12 December 2024

SSD-61000021 – Objection – 146 Arthur St, North Sydney - Build-to-Rent

1 Section East/West
SCALE 1 : 500

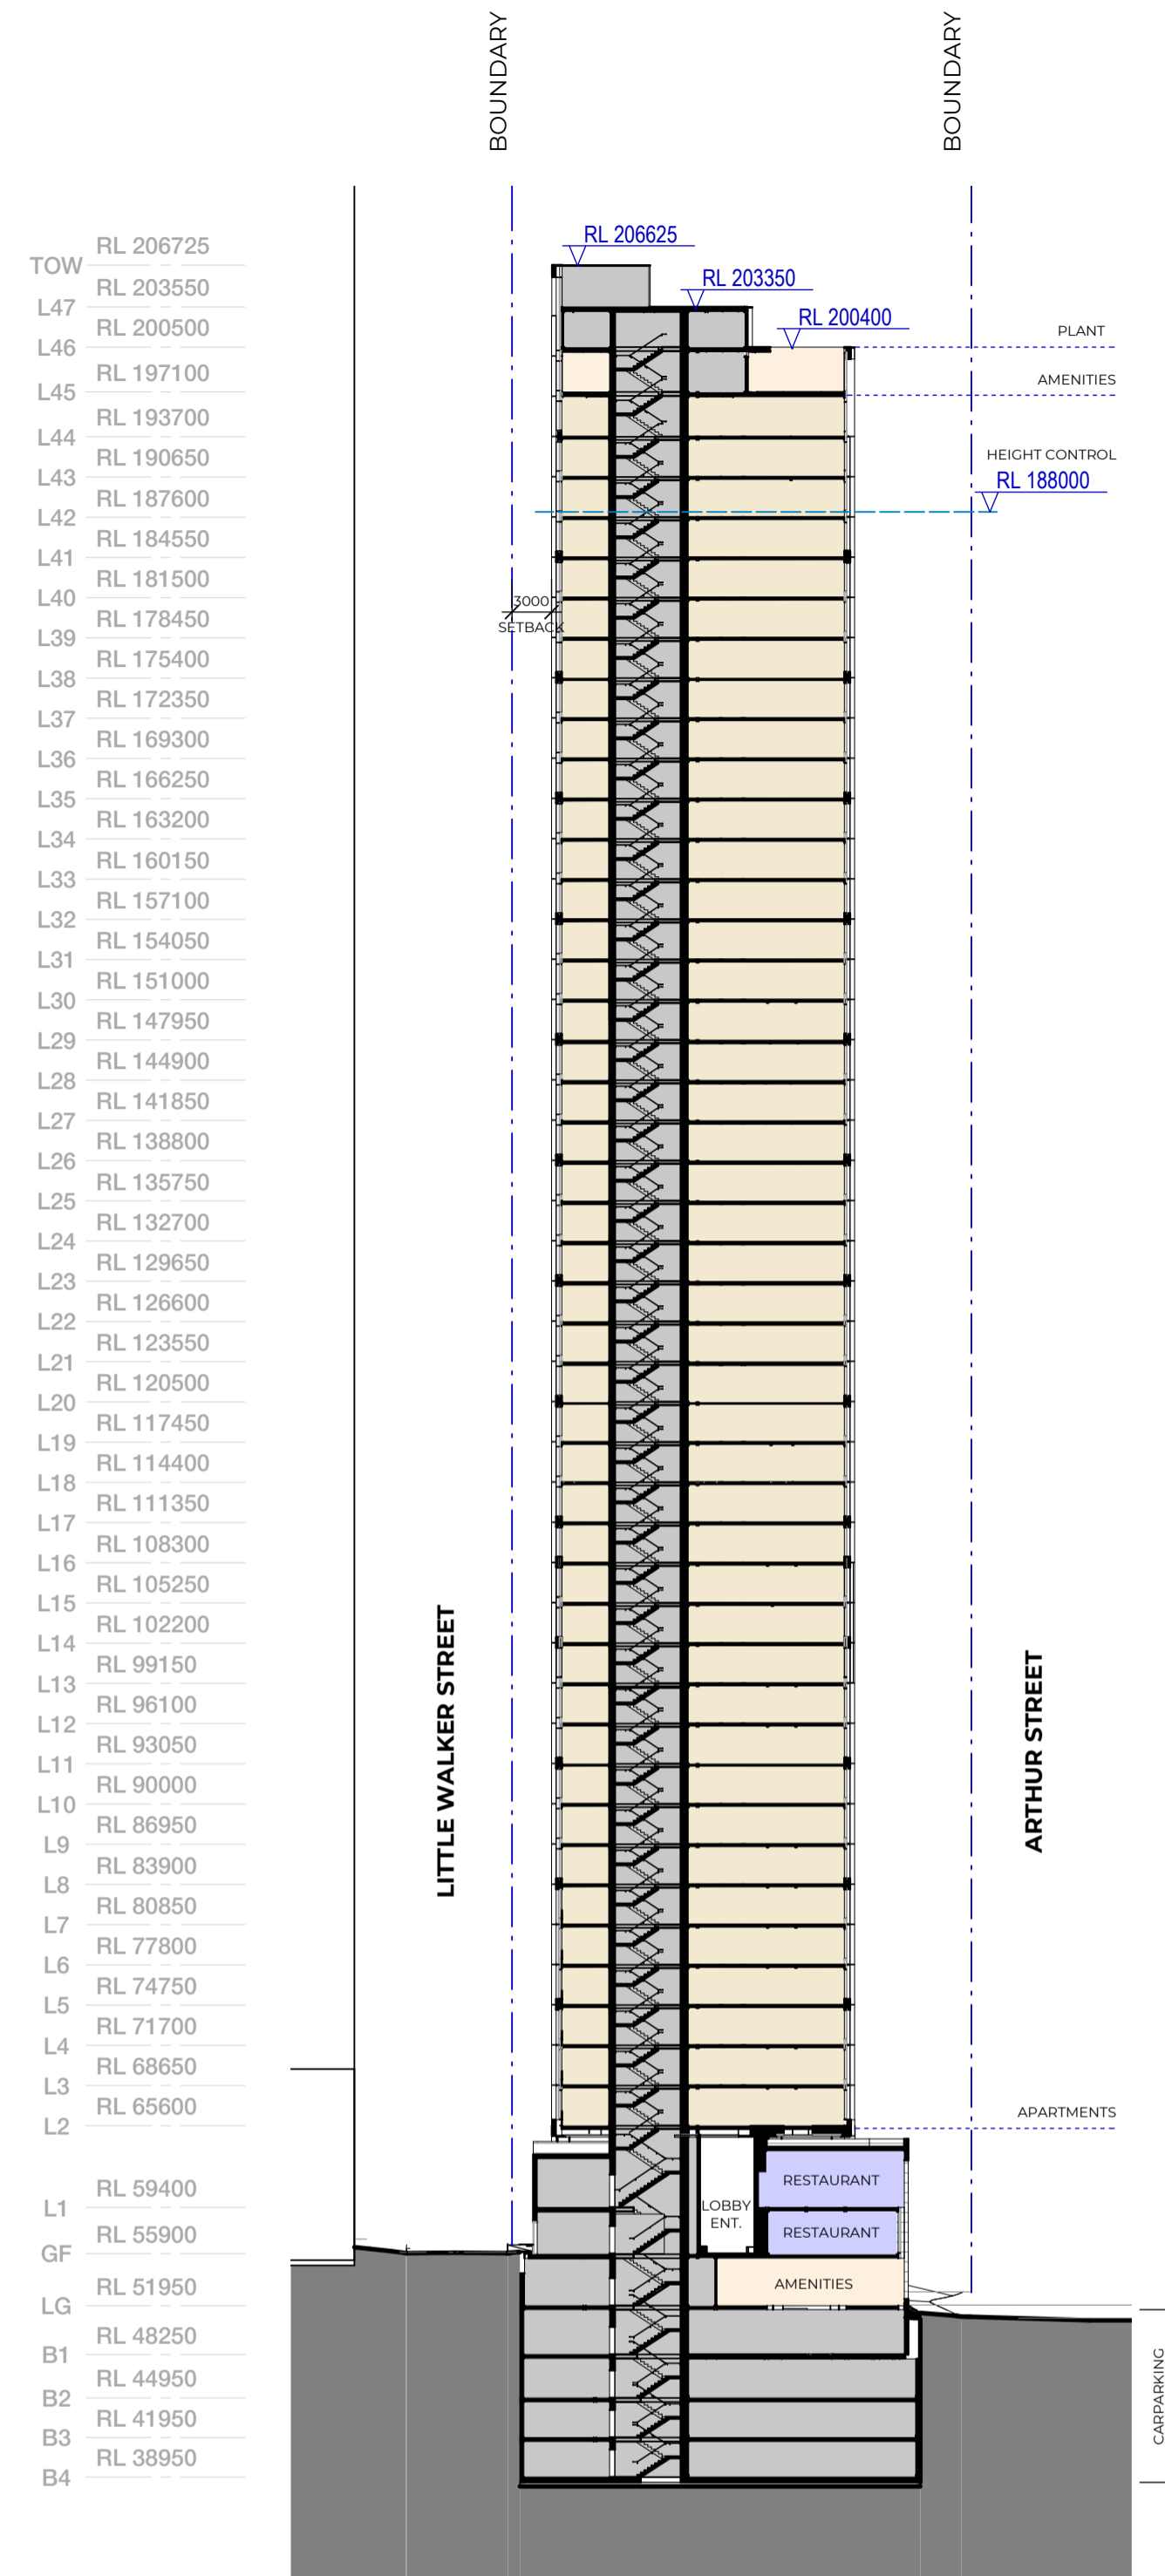
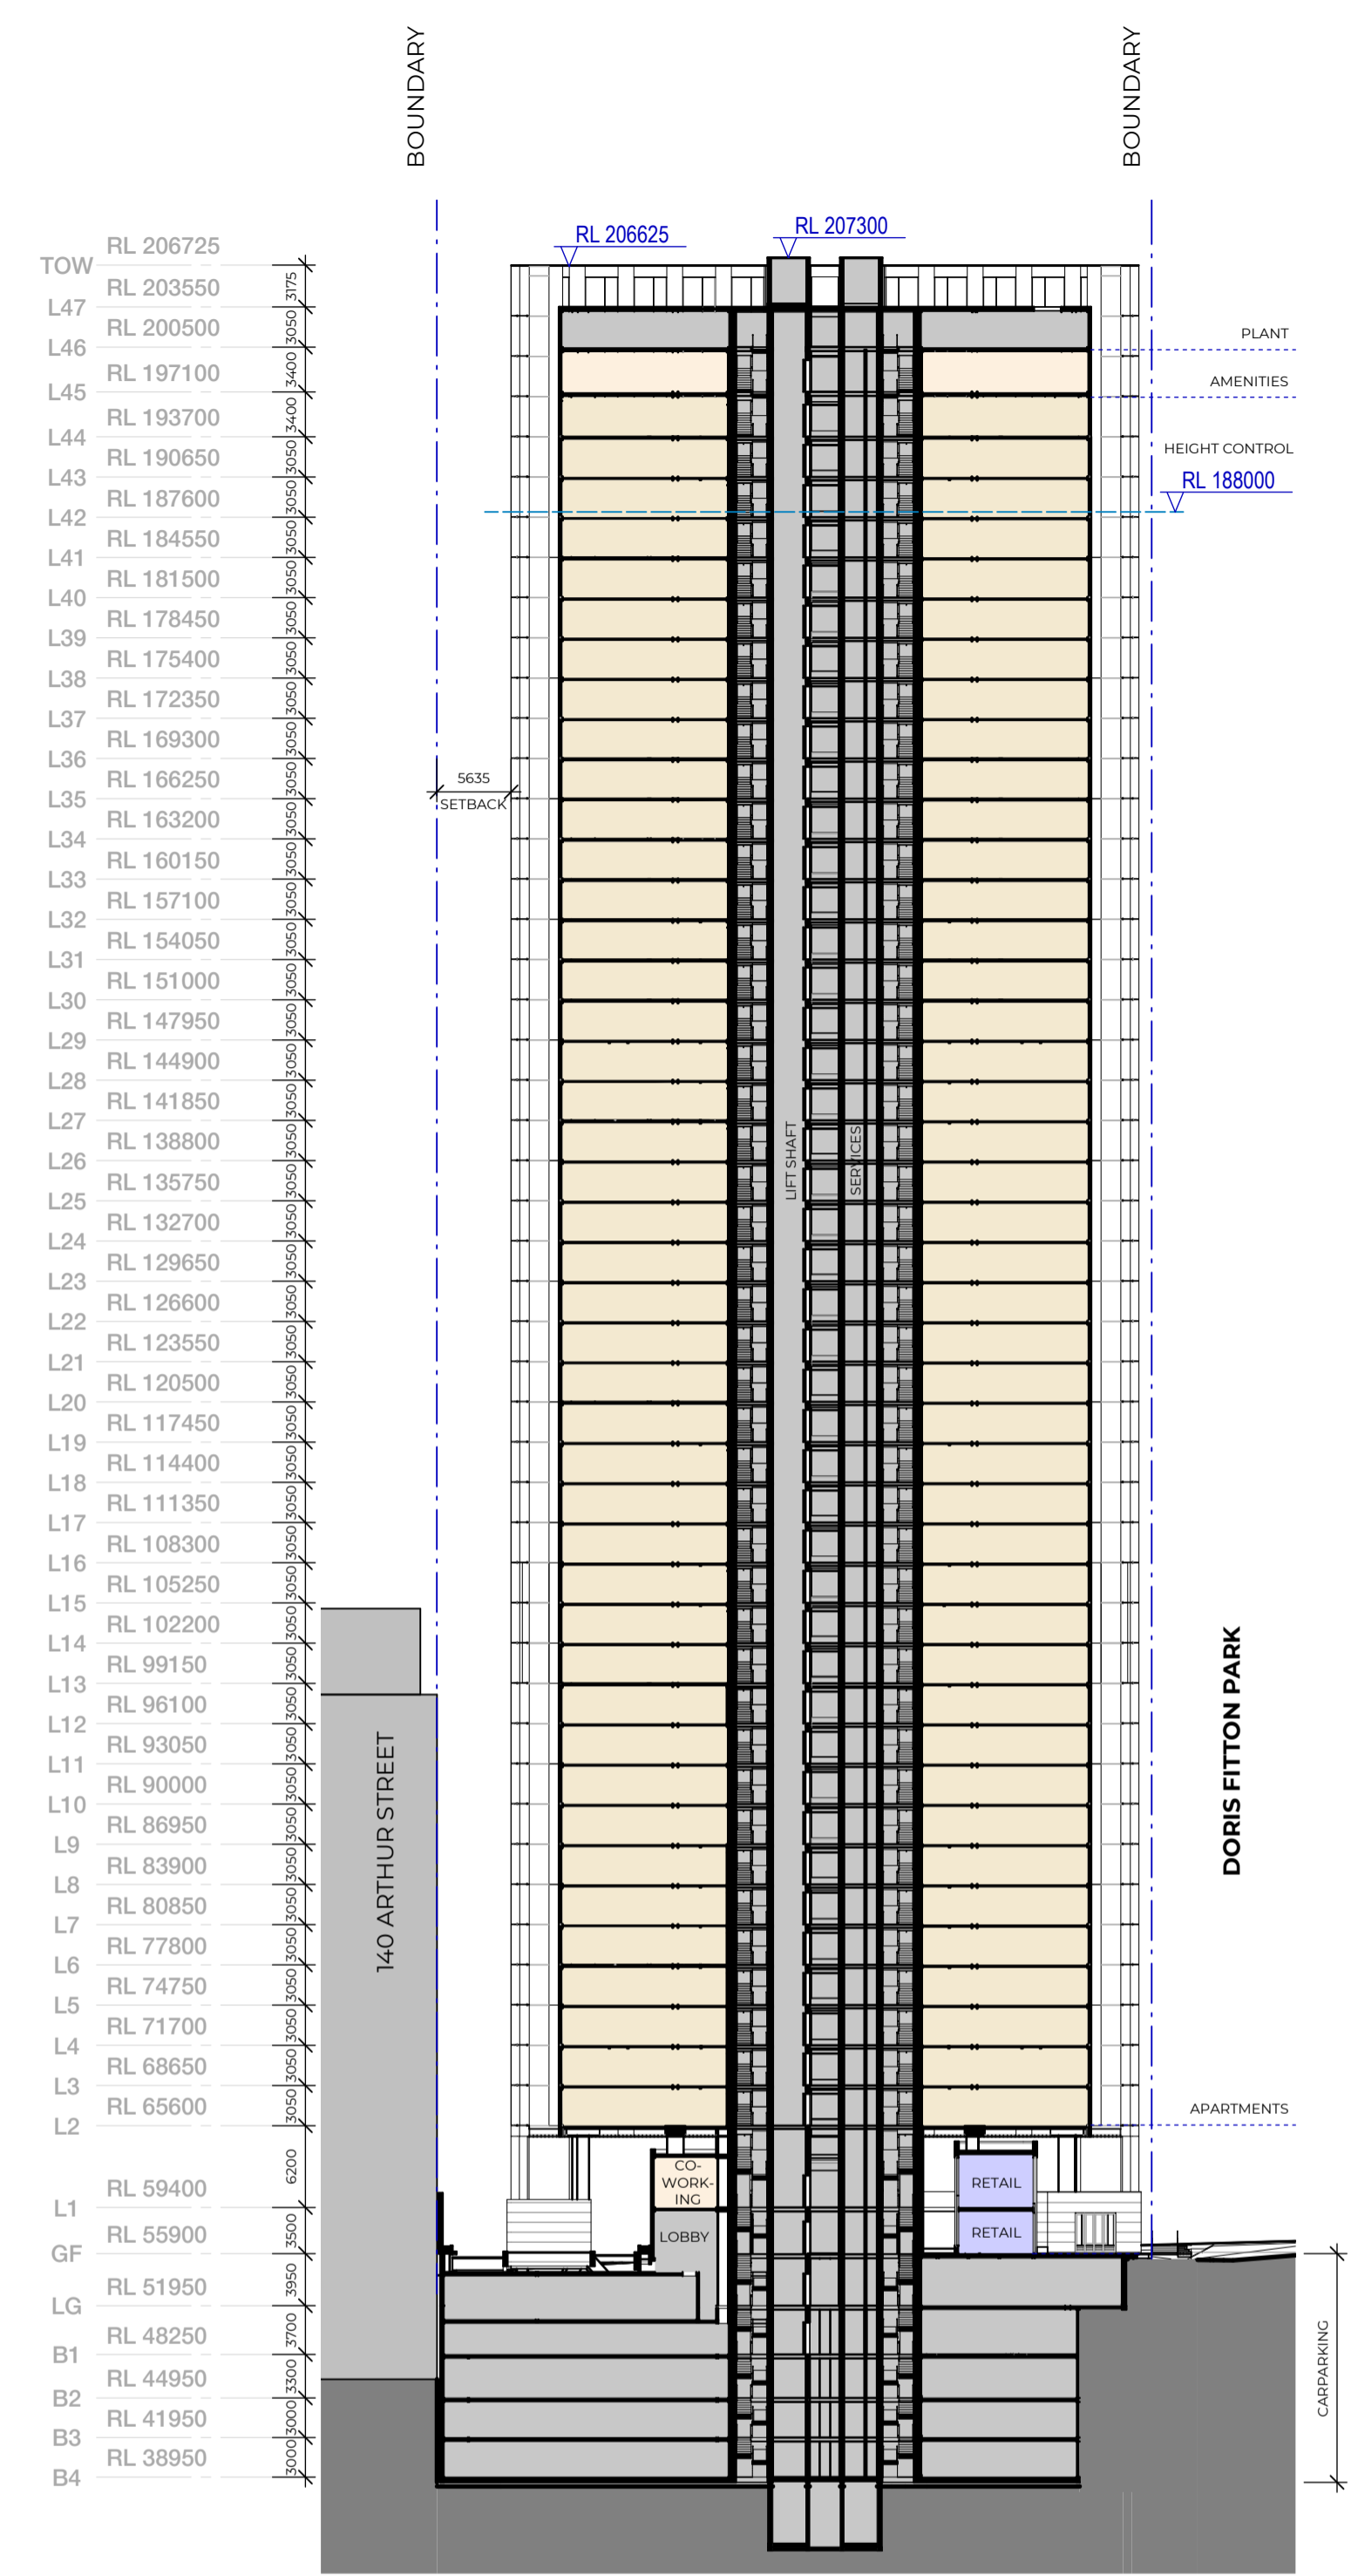
The Proposed Development exceeds the maximum permitted building height by 19.3m, or 10.27% of the standard to be varied. The proponent relies on clause 6.3 of the *North Sydney Local Environmental Plan 2013 (LEP)*. This exceedance will cause the loss of considerable views from the east-facing residences of the proposed development of the Freecity Property. These views are highly significant, to which our client raises the following concerns:

The impact on views could be mitigated by reducing the scale of the Proposed Development, specifically the height of the proposed tower form, to comply with clause 4.3 of the LEP. In this regard, we refer to the recommended massing reductions that are outlined at the conclusion of this submission.

- a 4m above-podium average weighted tower setback must be adopted along Little Walker Street;
- a 6m setback to Doris Fitton Park must be adopted. At minimum, this must be implemented in relation to the north-western aspect of the proposed tower form; and
- in the absence of sufficient environmental planning grounds to support the proposed height variation, the height of the proposal should be reduced to satisfy clause 4.3 of the LEP.
